STATEMENT OF RESPONSE TO AN BORD PLEANALA OPINION

STRATEGIC HOUSING DEVELOPMENT

PRIORSLAND
CHERRYWOOD SDZ
DUBLIN 18

1 CARRICKMINES LAND LTD.

Land Use Map

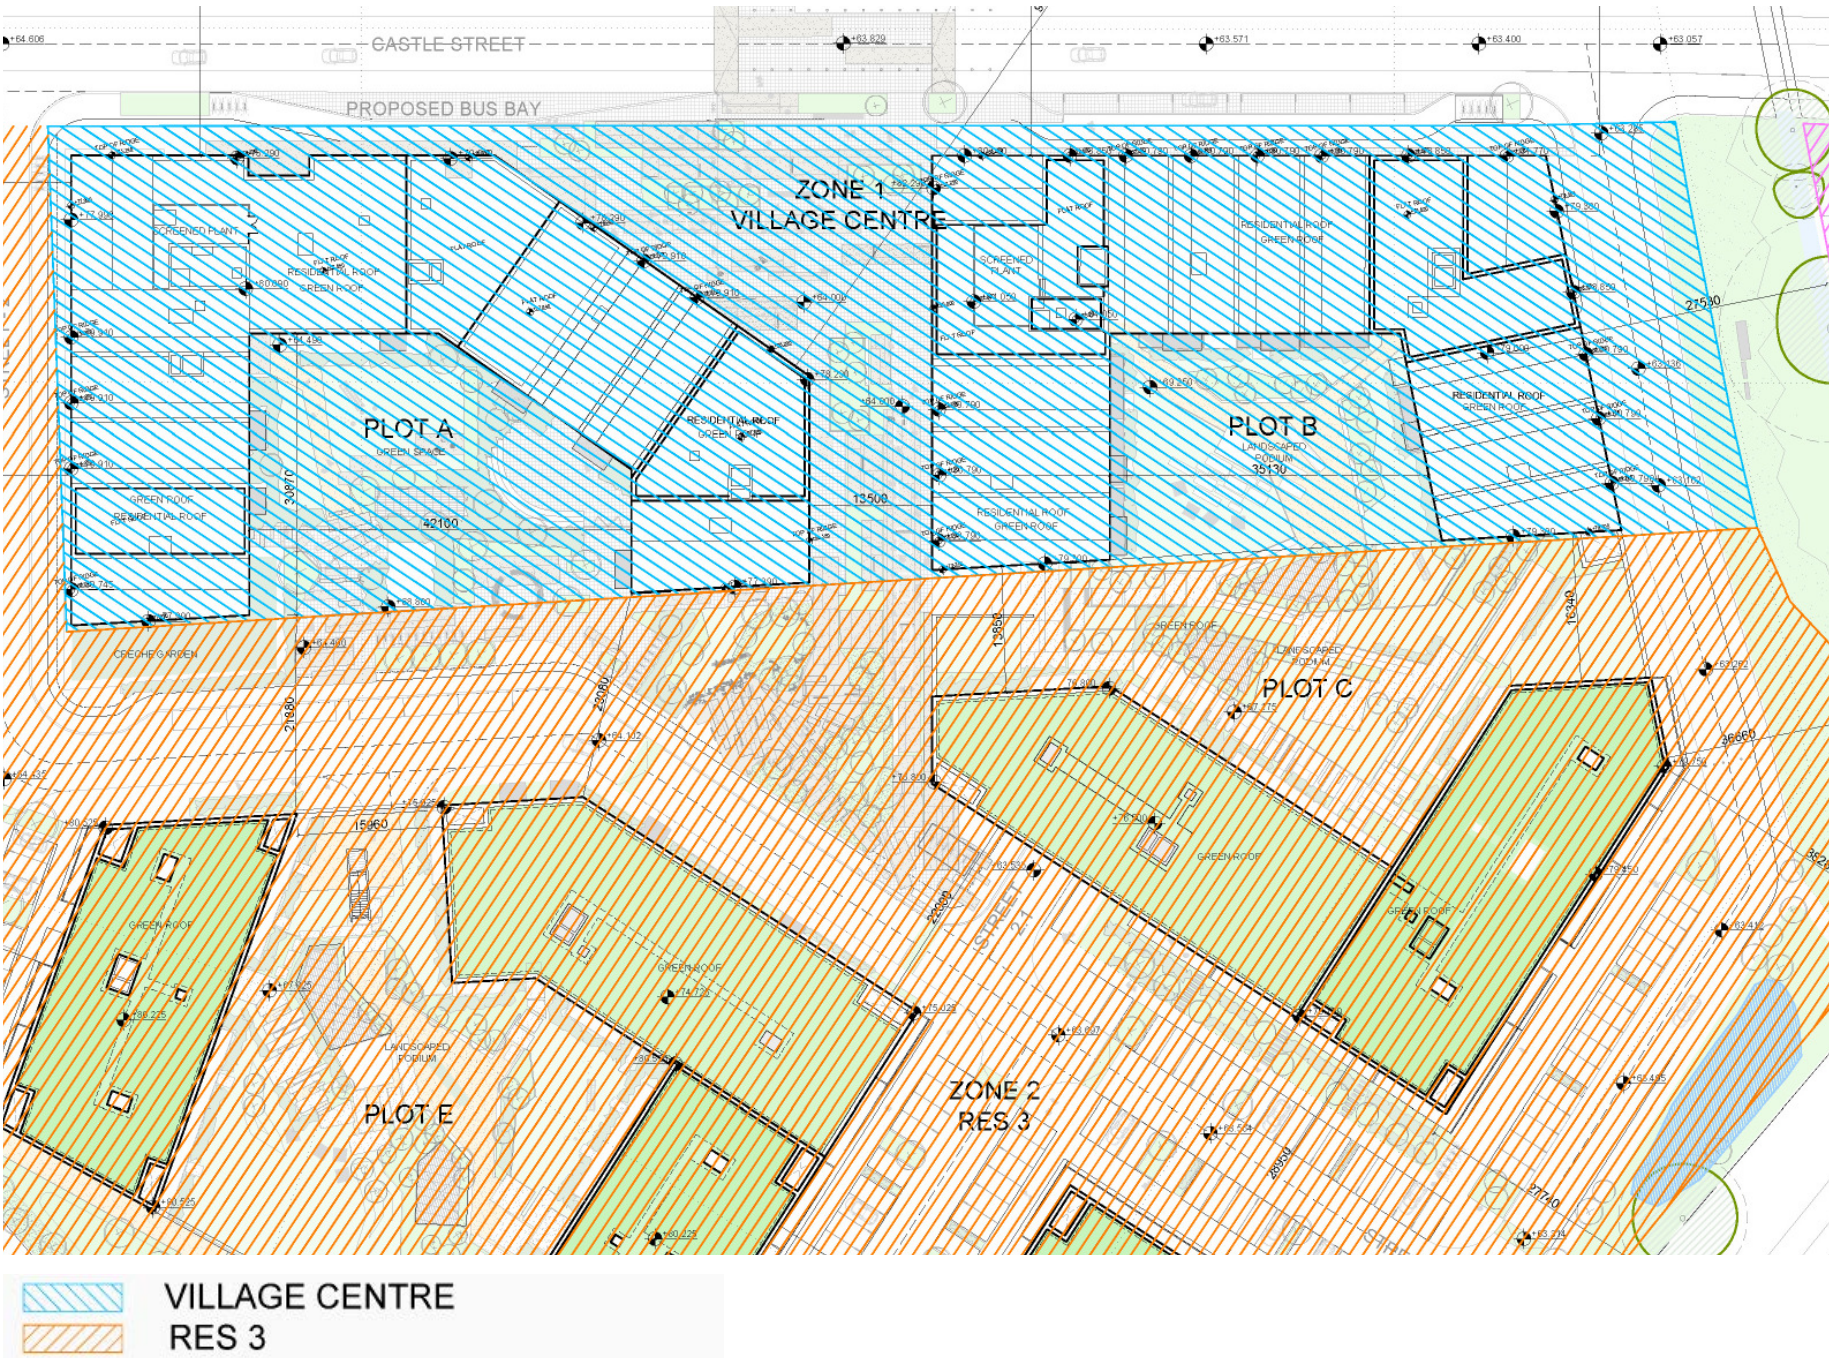
Overlay of land use map and proposed uses as specified in the SDZ.

It is noted that at SHD Stage 2 pre-planning consultation in 2020 a query arose as to whether all of the proposed Village Centre uses proposed were fully located within the Village Centre zoning as outlined in Map 6.3 of the Planning Scheme.

Please refer to the MOLA Architecture Design Statement and the Response to Item 3 on page 36 of same, which shows the proposed Village Centre Blocks A and B of the current proposal sitting fully within the Village Centre zoning and with Block C (all apartments) within the RES 3 zoning. The zoning boundary between the Village Centre and RES3 zoning is clearly shown and it is evident that no Village Centre elements are sitting within the RES3 zoning.
